## **Boston Alternative Energy Facility**

Response to Environment Agency's queries on  
Estuarine Processes (Clean)

Document Reference: 9.44(1)

Date: 24 March 2022

Figure 1.1. Ship Wash Wave Height Development over time as a Vessel Passes a Point (Gourlay, 2011)

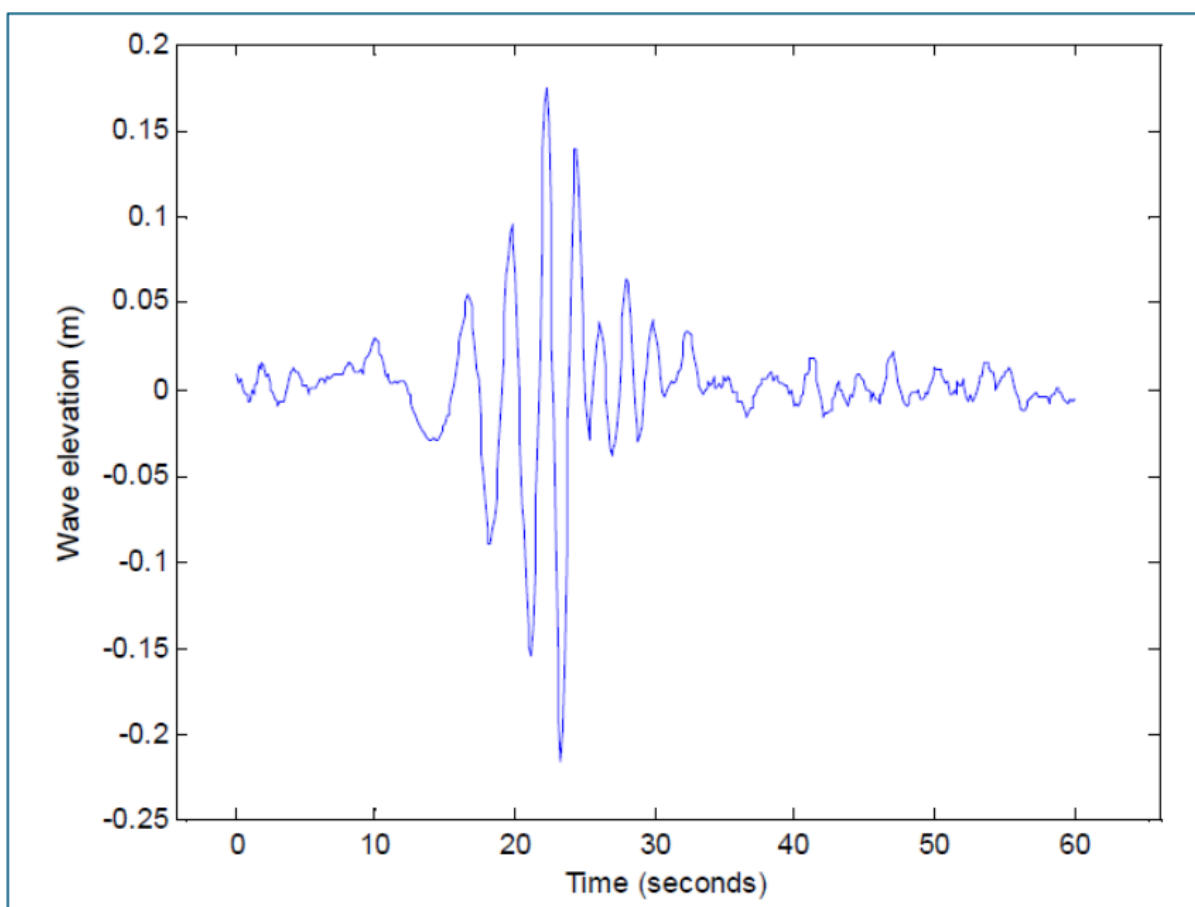
4.6. *The assessments of ship wash in Chapter 16 - Estuarine Processes of the Environmental Statement (document reference 6.2.16, APP-054 ) do not appear to take into account the variations in ship wash from the speed and size of the different ships expected due to the development. We note that this assessment has been done in Chapter 17 – Marine and Coastal Ecology of the Environmental Statement (document reference 6.2.17, APP-055). Ship wash will vary depending on the size and speed of the vessel. Smaller craft, travelling at greater speeds, will produce a larger and more energetic bow wave and stern/propeller wash, although for a shorter duration.*

4.7. *Ship wash may also be more severe when vessels designed for higher speeds are restricted to lower speeds, such as pilot boats restricted to 4 knots as proposed for vessels passing ships moored at the proposed wharf. We also note that the REP1-027 (Deadline 1 Submission - 9.14: Addendum to Environmental Statement Chapter 17 and Appendix 17.1 - Marine Mammals) identifies that ships will be limited to 6 knots rather than 4, and we question what impact if any this will have on the effect of ship wash.*

4.8. *We therefore ask that the detailed assessment of ship wash requested above takes into account the variation of ship types and speeds expected in the location of the proposed wharf.*

*2.5. We are concerned to note that Paragraphs 3.3.5 and 3.3.6 in document ref REP7-003 (Outline Mammal Mitigation Protocol) states that the speed of ships cannot be effectively regulated to 4-6 knots as stated in document ref REP3-020 (Response to Environment Agency's Queries on Estuarine Processes), and is more likely to be in the order of 12 knots in places along the Haven.*

*2.6. We consider that the evidence in document REP3-020 is therefore out of date and must be revised to demonstrate that the impact of ship wash at these speeds will not lead to increased rates of erosion affecting the ecological quality of the water body and/or undermining the toe of the flood defences.*

- 1.3.7 It is likely that ship wash may vary as the size and speed of the vessel vary. With respect to the sizes of the vessels using The Haven, they will be of a very similar size than the commercial vessels already using The Haven, and so from the perspective of size alone, the ship wash generated by them should be no greater than exists already. With respect to the speed of the vessels using The Haven, signage is present stating 'six knots' but this is not a speed limit and this is not enforced the Port of Boston as the Statutory Harbour Authority who instead rely on the Convention on the International Regulations for Preventing Collisions at

Sea, 1972 (COLREGS) 'safe speed'. In the case of large shipping, safe speed is set by the onboard pilot and is based on the prevailing circumstances, conditions and proximity of other vessels. The actual speed will vary depending on the type and size of the vessel. It is accepted that smaller vessels travelling at higher speeds would potentially create ship wash waves that are relatively high, but they would exist over a shorter period of time, than for a larger vessel travelling more slowly. Typically, waves created by ship wash only last for less than 10 seconds with peaks heights of around 0.4m (**Figure 1.1**) (Gourlay, 2011). Hence, if higher waves are generated over a shorter period of time (by faster moving small vessels), they would produce similar levels of energy at the shoreline compared to relatively low waves generated over a longer period of time. The possible height and time scale combinations that could be caused by different vessel sizes and speeds, would effectively balance each other out in terms of the energy impinging on the shoreline.

baseline ship wash is eroding the adjacent banks, and this is the premise upon which the assessment is based. So, even though there would be variations in the type of ship wash encountered at the shoreline, it is accepted that as a worst-case scenario, there is likely to be some erosion. Hence, an increase in the shipping traffic would result in an increase in erosion. However, the key element in the assessment set out in the ES, is whether any increase in erosion induced by extra vessels that are visiting the wharf is significant or not. This response is restricted to the vessels visiting the wharf only, because the numbers of other vessels in The Haven (that are not visiting the wharf) would continue to move past the wharf in either direction is the same as the current baseline case, as would be the magnitude of ship wash generated by them. The rationale for the balancing out of wave energy caused by variations in vessel speed is outlined earlier in this section.

- 1.4.4 A typical ship wash wave is about 0.4m high, lasting for about 10 seconds and reducing to less than 0.1m after that (**Figure 1.1**) (Gourlay, 2011). In this case, a wave 0.4m high would impact on the opposite shore a short time after the direct ship wash wave impacts that shore. So, for every day of a year the number of ship wash events on the bank opposite the wharf will be doubled compared to the current baseline. If a situation arises where the berths are empty, ship wash would be restricted to the direct wave from a vessel travelling past the wharf, and there will be no reflected wave off the sloping revetment and wharf piles for the reasons stated in Section 1.2.1.
